WEST SUSSEX COUNTY COUNCIL CONSULTATION

TO:	Arun District Council FAO: Silvie Steiningerova
FROM:	WSCC – Highway Authority
DATE:	7 October 2025
LOCATION:	Land West of Holly Drive Littlehampton
SUBJECT:	LU/184/25/DOC Approval of details reserved by condition imposed under LU/47/11/ relating to conditions 21-Ecological Management Plan, 22-Construction Method Statement, 23-details of construction compound and 26-Roads Construction Programme (see LU/185/25/DOC for approval of details reserved by condition imposed under LU/47/11/ relating to condition 10-surface water drainage). An amendment received to the above application dated 19th September 2025 relating to: Conditions 21, 22, 23 and 26. Substitute construction method statement received on 29th September 2025.
DATE OF SITE VISIT:	n/a (desktop study undertaken – site visited previously)
RECOMMENDATION:	More Information Required

Comments below solely respond to conditions 22, 23 and 26 (found in Construction method Statement produced by Persimmon Homes Ltd., Revision 02, September 2025).

Dwg. No.	001.1.TVAL.0100	Rev	P1
----------	-----------------	-----	----

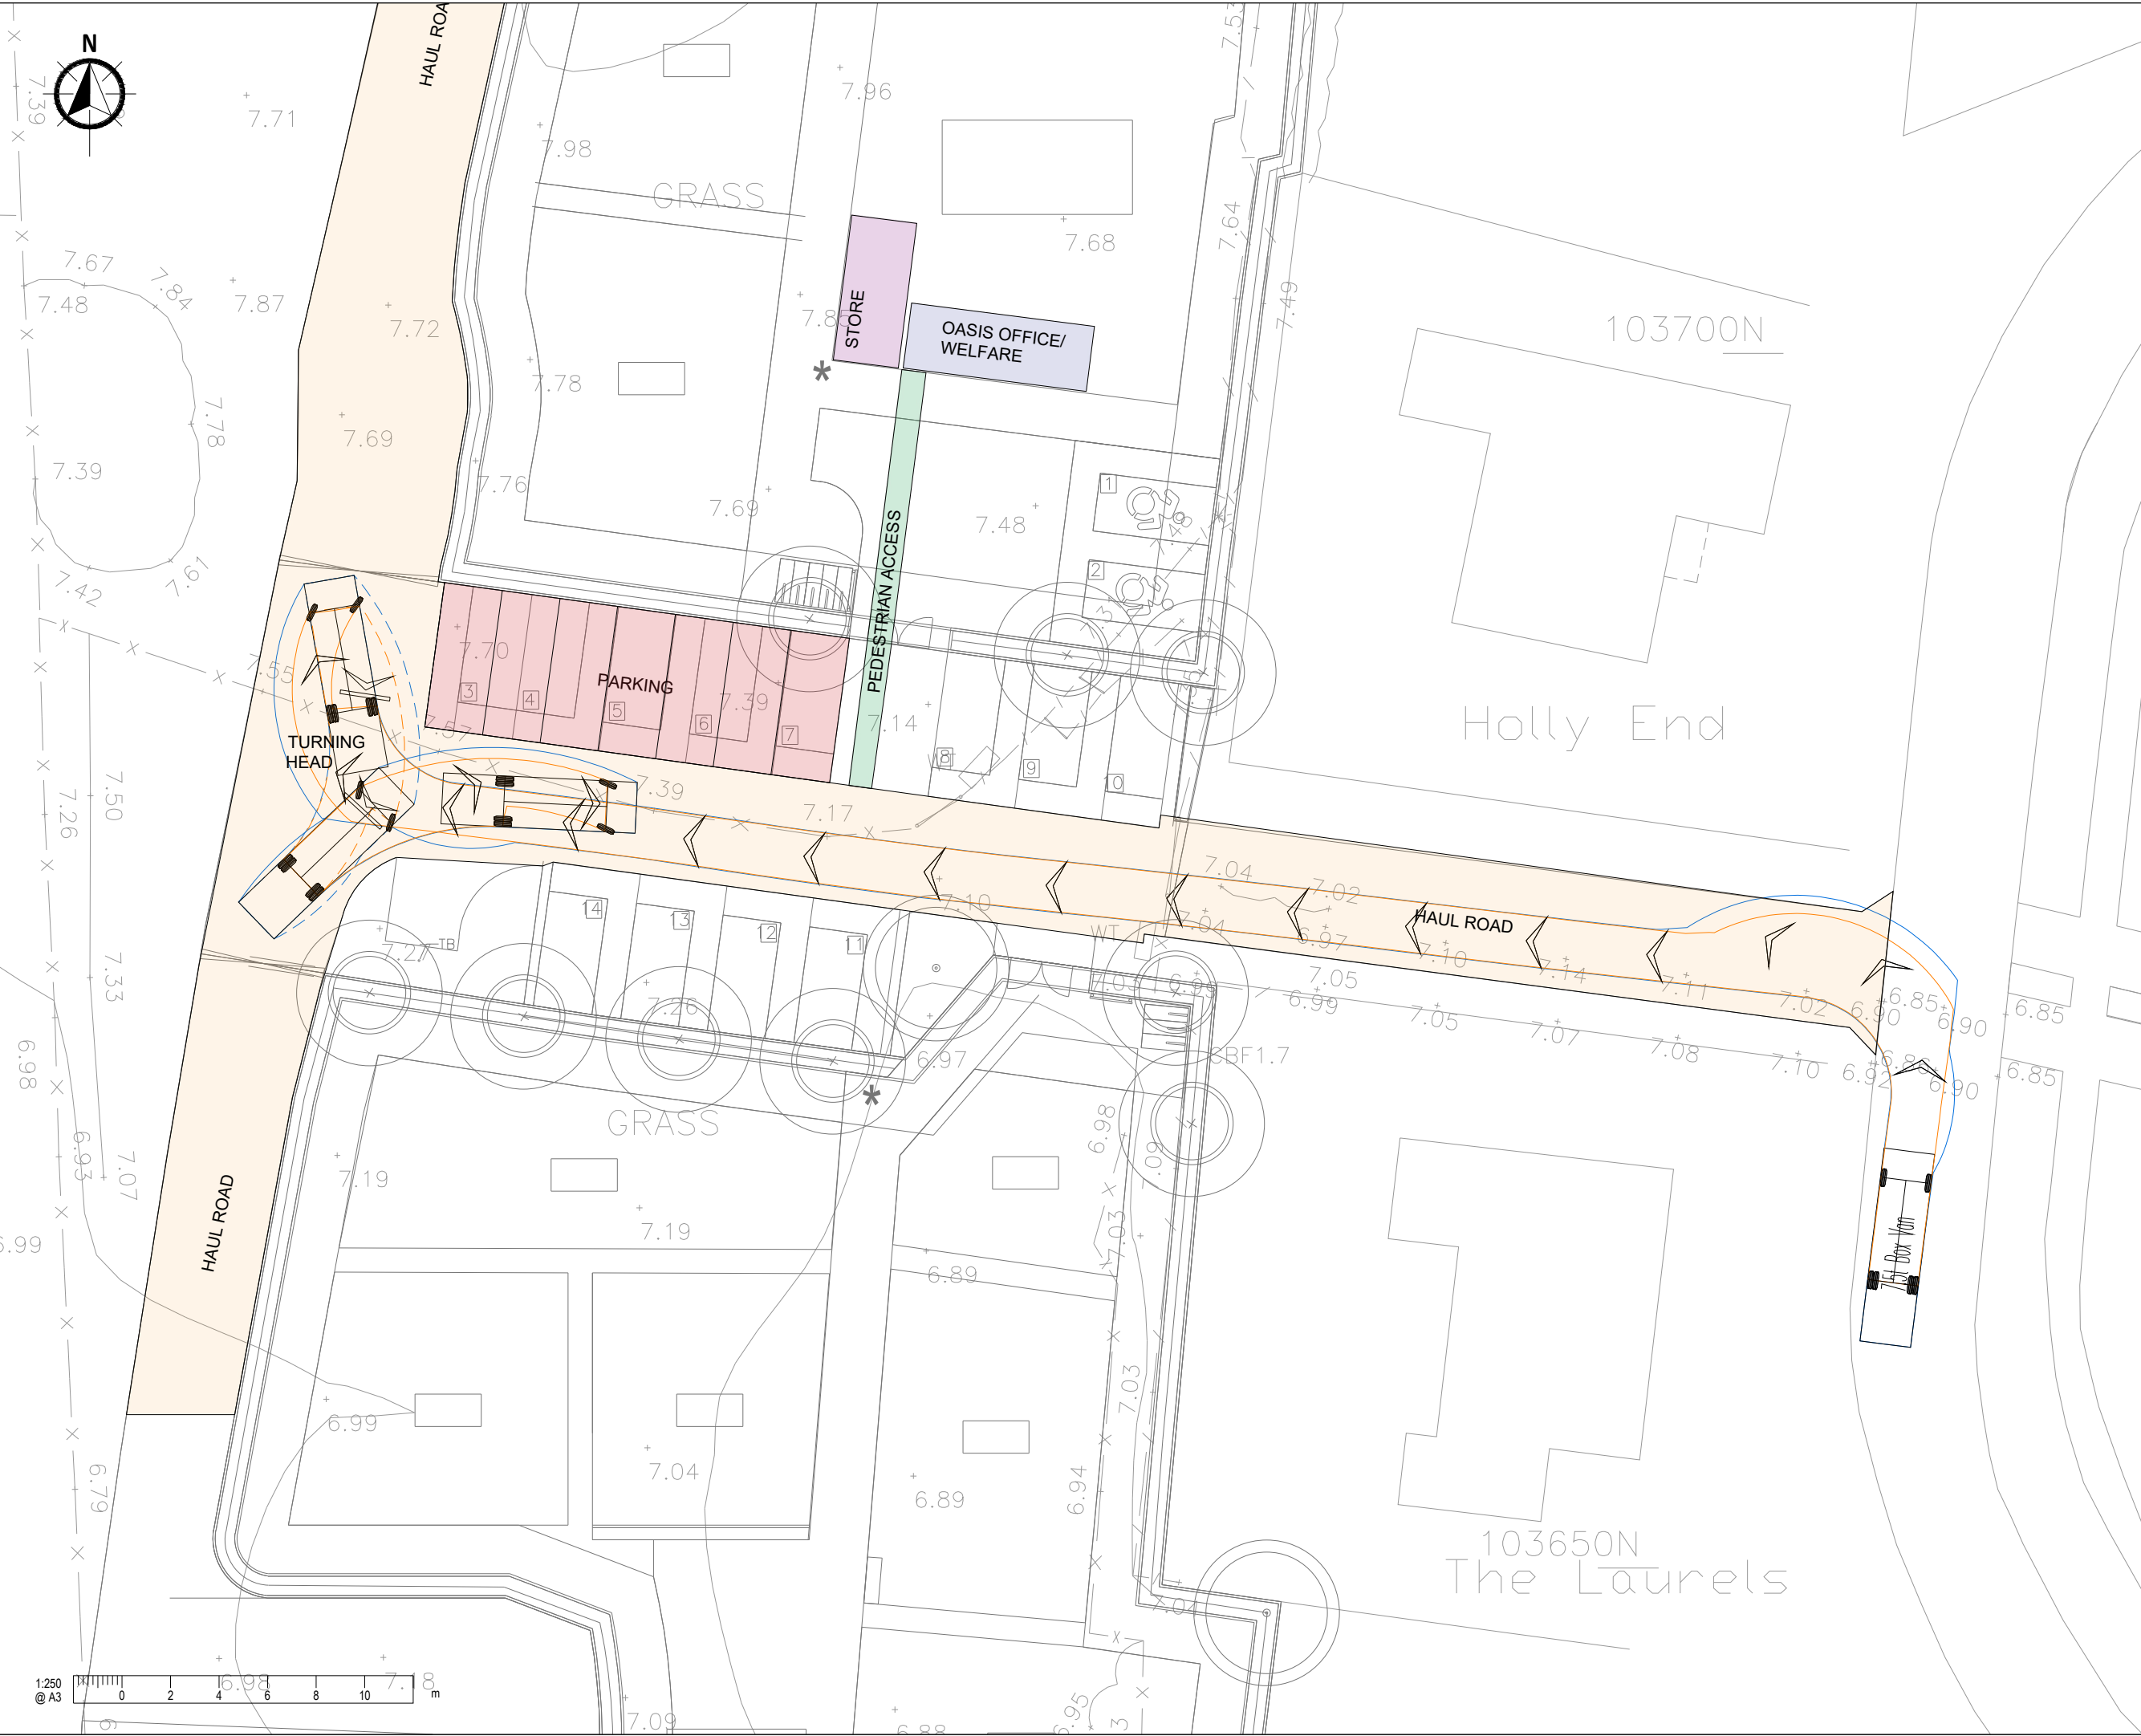
The applicant says that they anticipate no more than 30 Heavy Goods Vehicle movements will occur during a normal week. They continue by saying that all

construction traffic will approach and leave the site using the Nightingale Way Access, via the roundabout from the Lyminster Bypass. Construction traffic will need to access the Bypass from the A259 Worthing Road access (south of the site) until the Northern section of the Bypass (Santa Monica Way) is opened. No construction traffic will enter and leave from Holly Drive. However, Drawing No. 001.1.TVAL.0100 P1 seems to show that vehicles will enter and leave using Holly Drive via Toddington Lane. As such, the applicant should clarify access routing arrangements by way of a further description (noting that the Lyminster by-pass is now fully open to traffic) and a plan showing routing arrangements.

Additional to the previous point, the applicant should enter into a S59 Agreement (or very similar) with the Highway Authority to safeguard the public highway during the construction process.
